Your Ref: A/81/18/RES

Our Ref: NW/ARU/17/14D

RE:- Quiet Waters Roundstone Lane Angmering

Thank you for your correspondence of 24th October 2018, advising me of an Approval of reserved matters following outline consent A/132/17/OUT for appearance, landscaping, layout & scale for demolition of existing dwelling & the erection of 30 No. dwellings. This application is a Departure from the Development Plan application for which you seek advice from a crime prevention viewpoint.

Drawing Title:
Proposed Site Layout

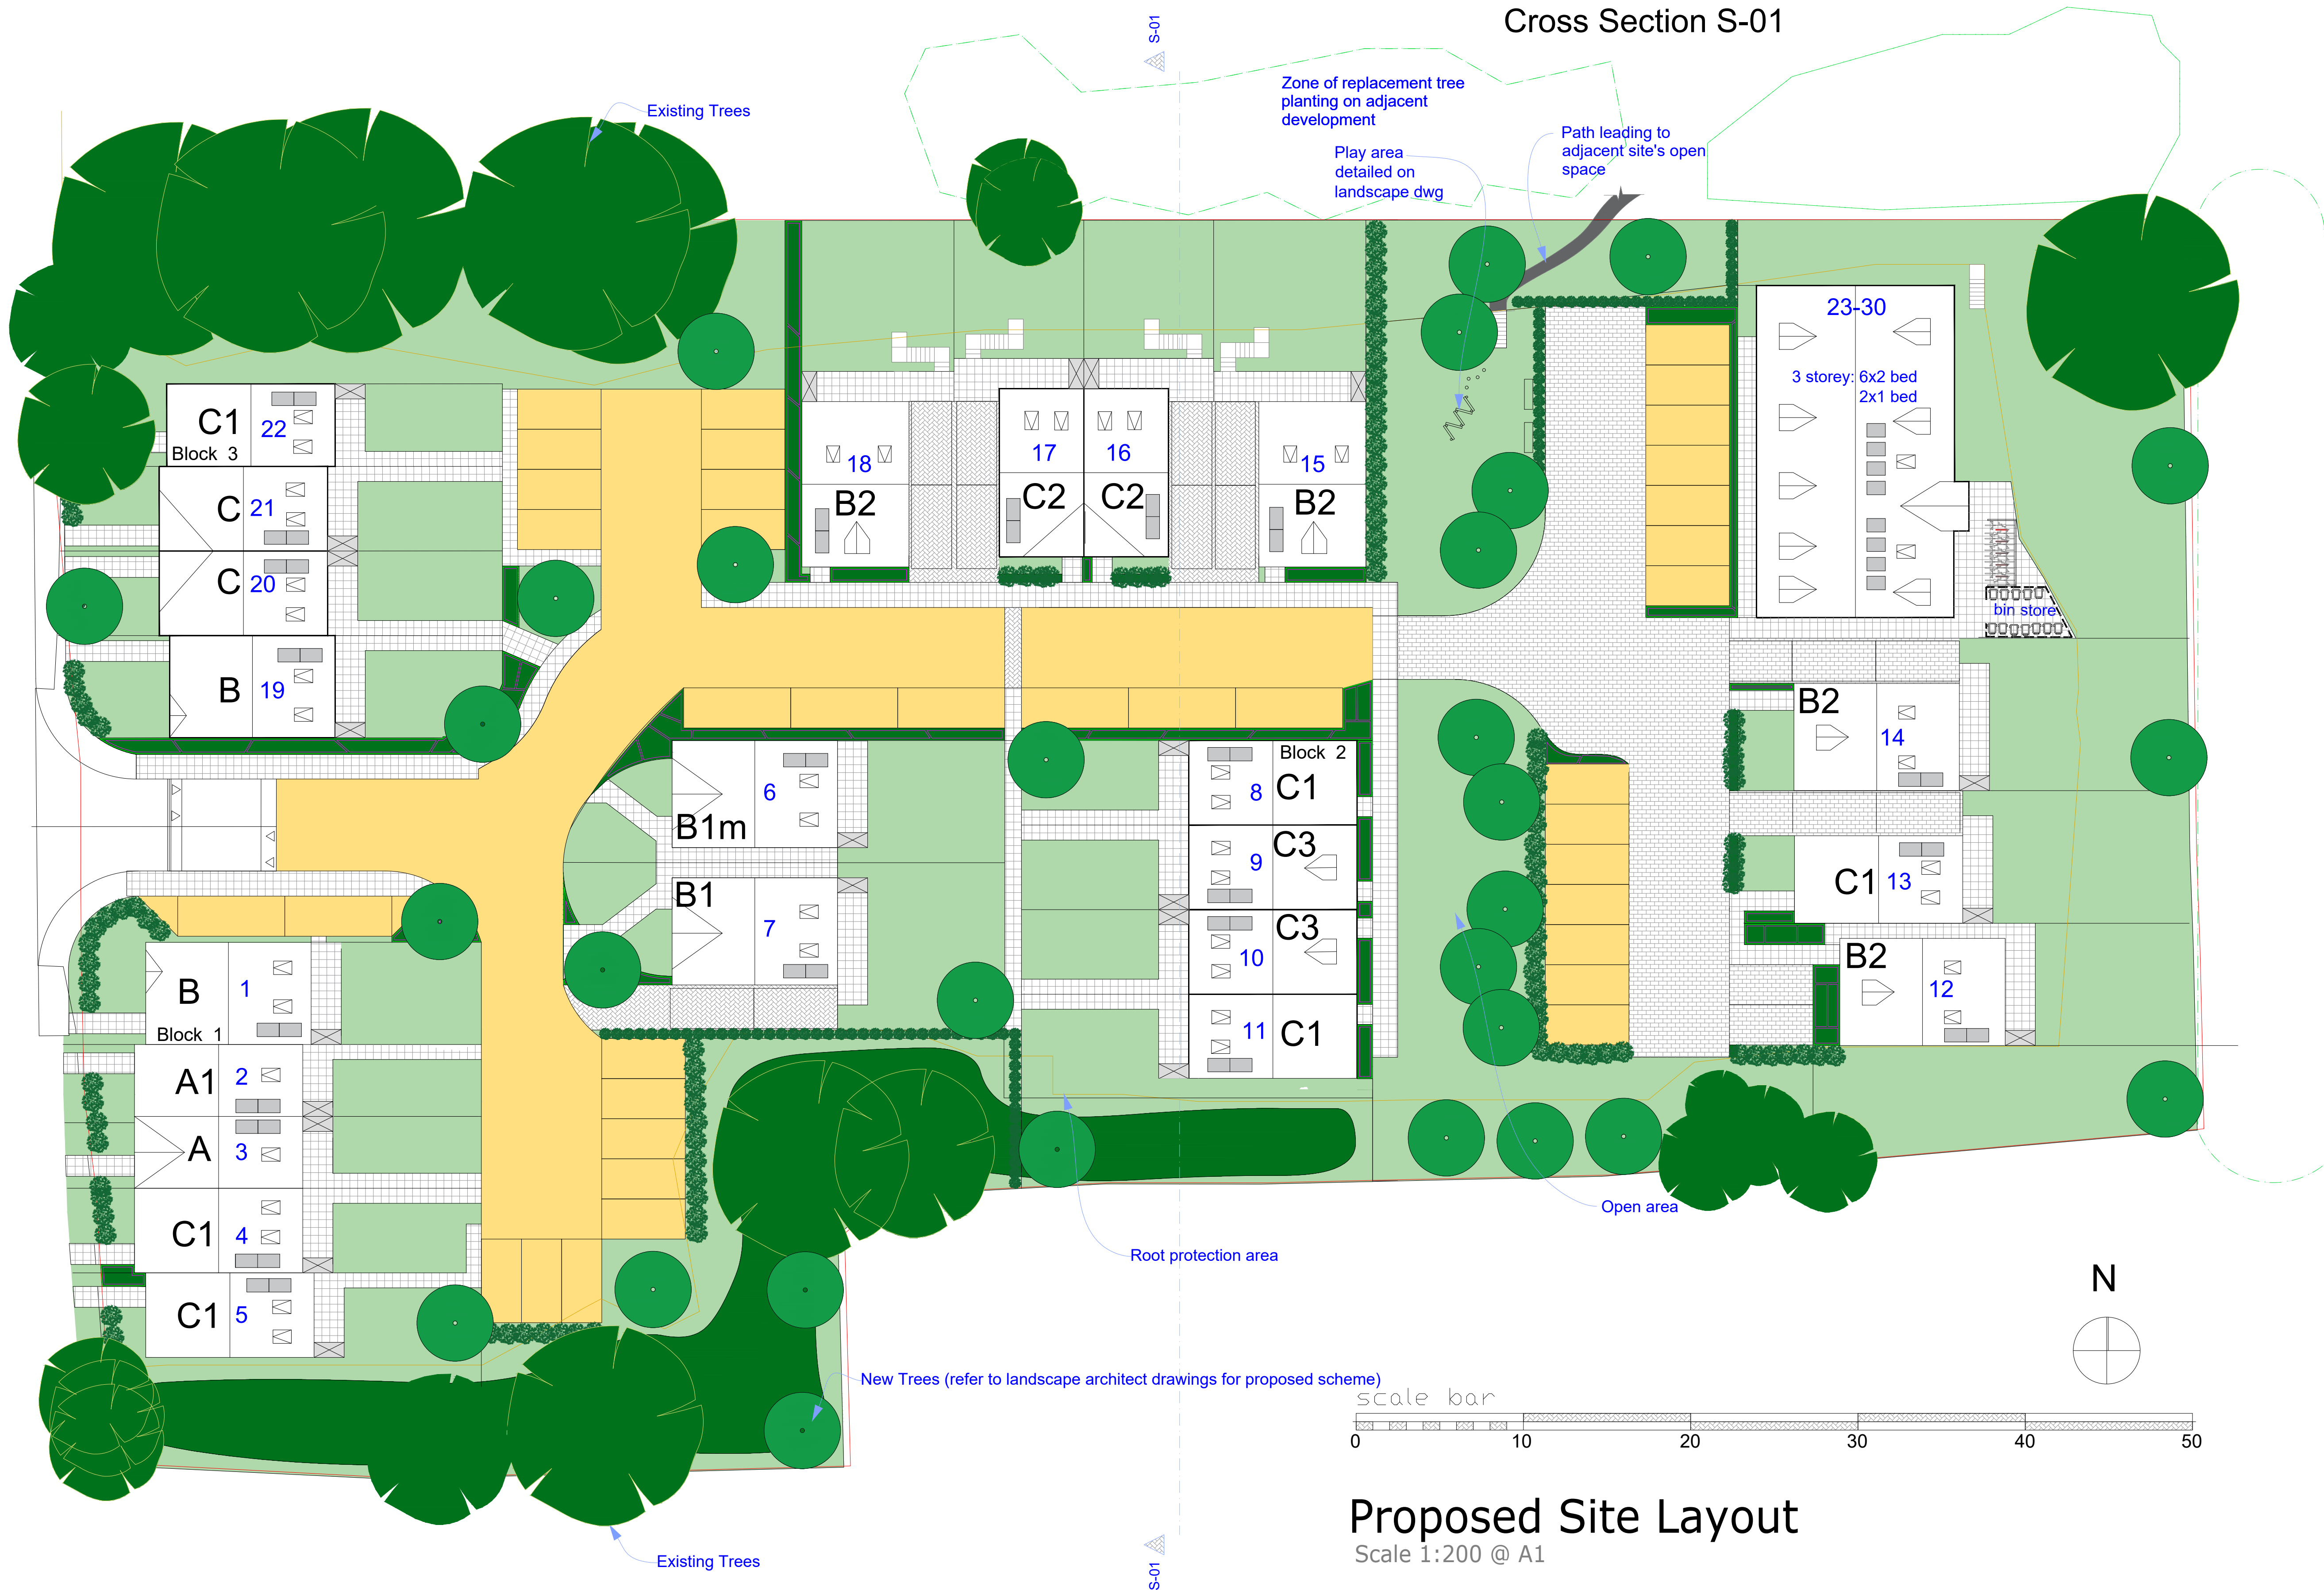
I cannot ascertain sufficient detail from 'Southmill's' plan (1006 Ang101 Rev 0 dated 25.09.18) to comment fully. I have also referred to Southmill's plan (1006 Ang 102 Rev E, also dated 25.09.18), but they both vary in their detail or lack of it.

In relation to communal parking areas, I recommend a knee high post and rail fence that would provide protection for the vehicle parked in the northern corner of the parking bay, behind plot 8. As it is vulnerable to vehicles turning in and out.

I am pleased to see a low hedgerow is situated between the parking area outside the apartment block and the 'Area of Play' to reduce any likely hood of reversing vehicles coming into contact with children around the seating area.

I note the larger apartment block consist of 8 dwellings. Access to the 3 ground floor apartments is via their own individual front doors at ground level facing the parking bays and road. Access to 1 apartment at 1st floor level is via its own staircase accessed at the rear of the building. Access to a further 2 first floor apartments is via a separate staircase at the rear of the building which also leads to 2 further flats at second floor level.

I have concerns that the rear access doors to the stairwells of the first and second floor apartments are located at the back of the building and not overlooked at all by other dwellings. To gain access to the ground floor doorways of the stairwells requires all occupants to follow the side path to the rear of the building.

The doors to the stairwells at the back of the property are out of view. The rear access doors to the southern stairwell will see a higher level of activity by residents than those doors at the front of the property.

Drawing Title:
Proposed Materials Layout

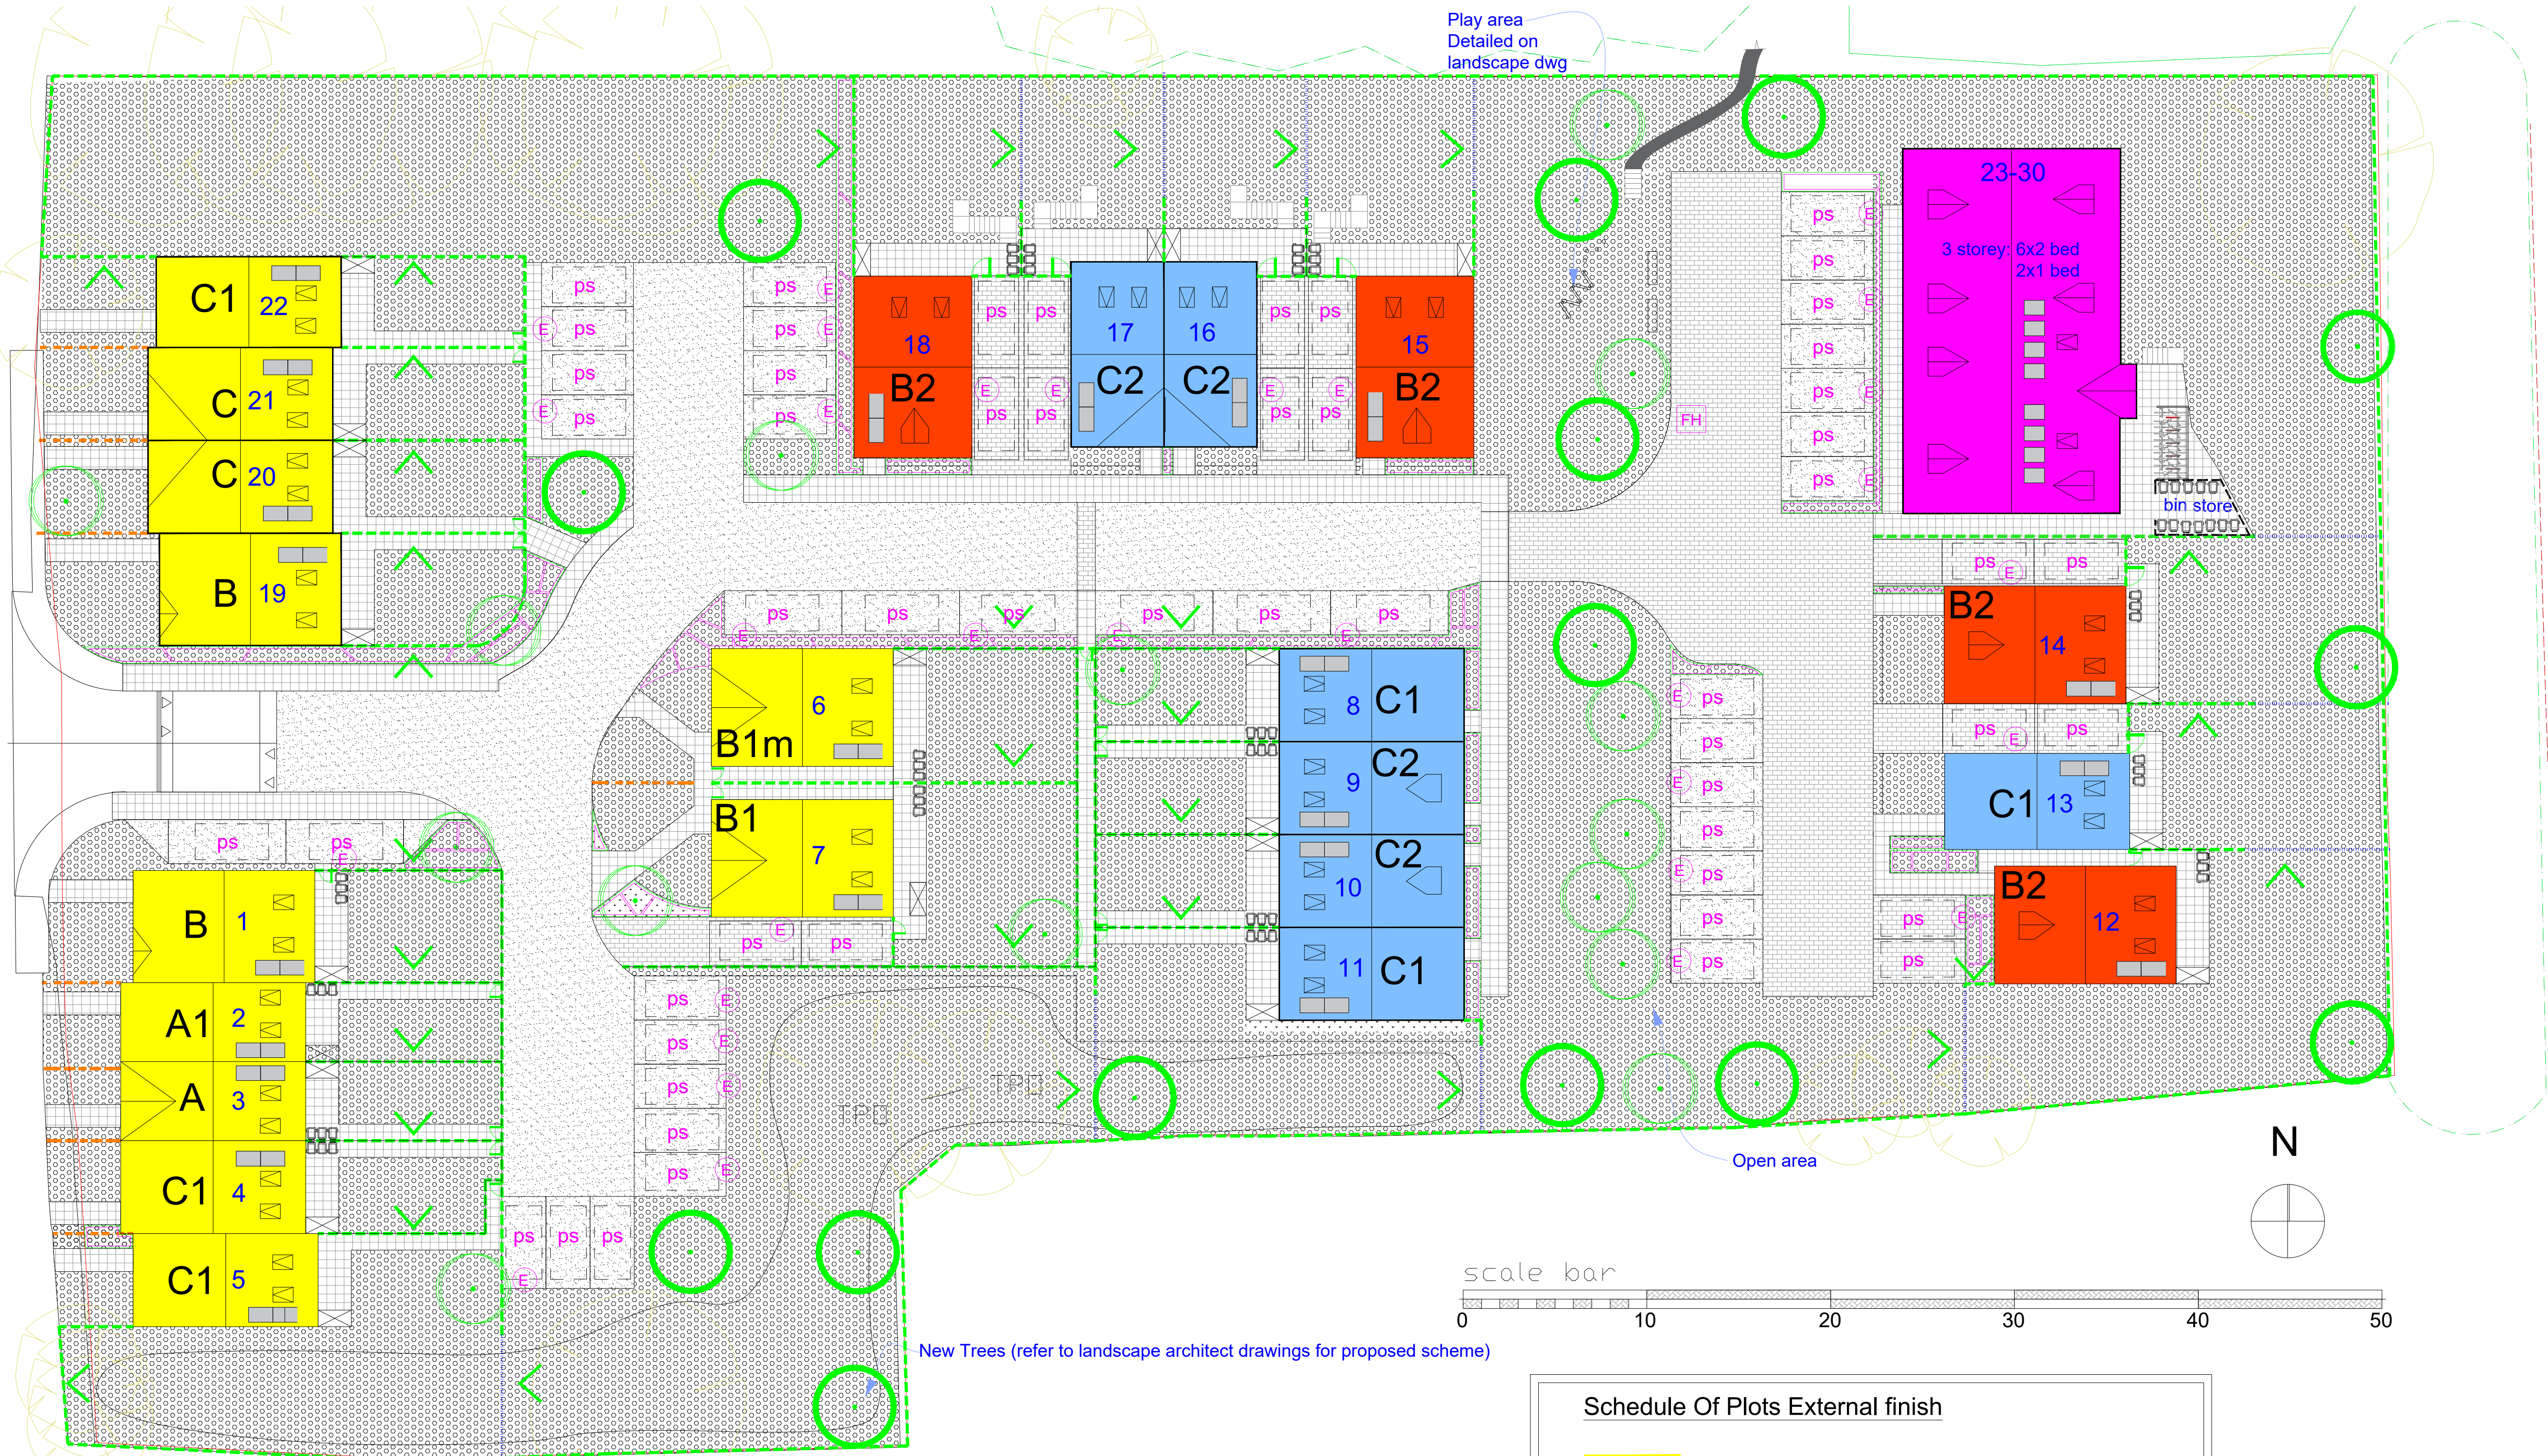
I would recommend that 1.8m high close boarded wooden fencing installed to the rear north side fence of plot 14 along its entire length to protect the garden from the amenity area of the apartment block.

The south side fence of plot 12 would benefit from 1.8 metre high wooden close boarded fencing along its whole length as it offers a better degree of protection to the garden and to that of 13 and 14 as well.

The south side fence of Plot 11 running west to east would also benefit from the same type and height of perimeter fencing.

Again at plot 5, the plans do not indicate any detail of fencing around the back garden. I would recommend 1.8 metre high close boarded wooden fencing across its southern side and along the back of all plots 1 to 5 and plots 19 to 22.

Lastly, for the east side rear garden of plot 15 and the west side of plot 18's rear garden, I would recommend 1.8m high wooden close boarded fencing. Likewise for the side & rear gardens of plots 6,7,8,9,10,11. Any hedgerows must be dense to prevent unauthorised access through holes between bushes and to prevent young children finding their way out or unwanted animals entering the gardens.

Plots 2,3,4 and 5 would benefit from lockable gates as their rear gardens back on to the parking areas. Occupants are most likely to use the rear gates to access their vehicles. They would benefit from 1.8 metre high wooden close boarded gates to match the fencing. Gate locks that can be key locked from both sides would encourage residents to also lock the gate after leaving the back garden, which would then help deter potential offenders from reaching the rear house windows by providing an increased layer of security for each property.

I have a concern regarding the gated access path to the back gardens of plots 6&7 and 8,9,10,11.

The proposed 1.8m high wooden close boarded fencing on both sides will enclose the pathway and provide a secluded route obscured from view for unauthorised access to the back gardens.

I would again recommend 1.5m high wooden close boarded fencing topped with 300mm of wooden trellis on one side or both sides of the path, which will provide a better view of it by residents but still provide some privacy from overlooking each other's gardens.

The entrance gate to the communal path should be either provided with a 'keyed alike' gate lock or each of the back gardens provided with back gates that can be locked or bolted.
